**CHURCH's #695**  
- 5407 Central NW -

- Possible alternative driveway entrance, with flared ramp layout, and sidewalk pushed back into an easement on the property.

DWG. 2425

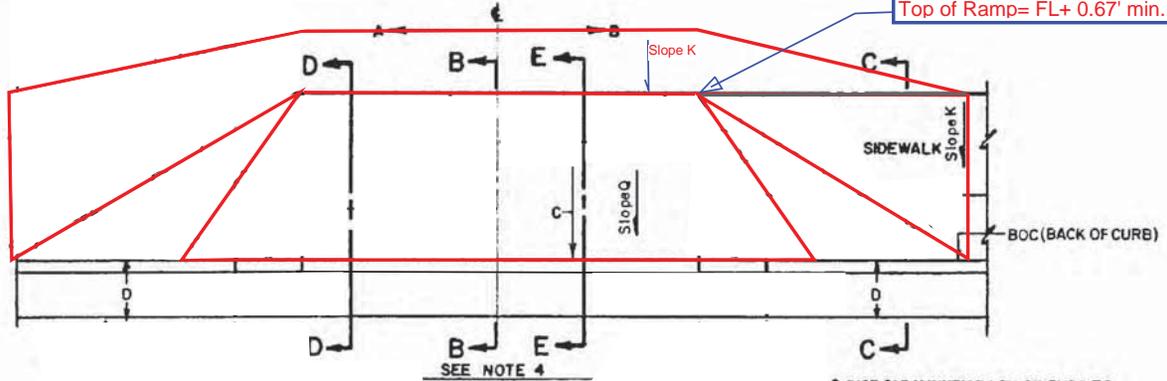
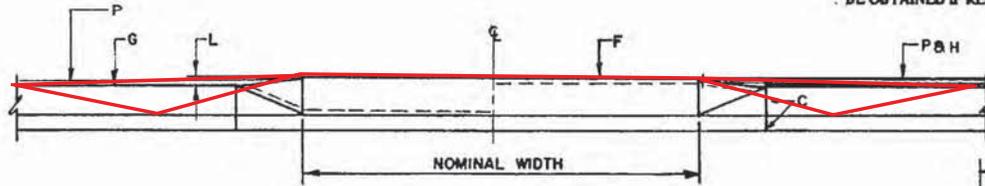
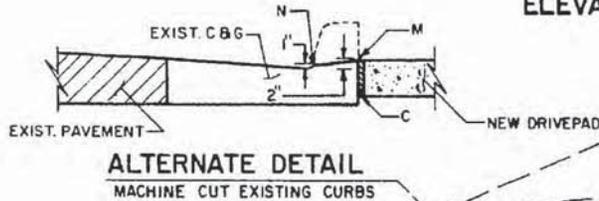
- You may be able to pull it all out into the R/W if R/W depth is adequate.
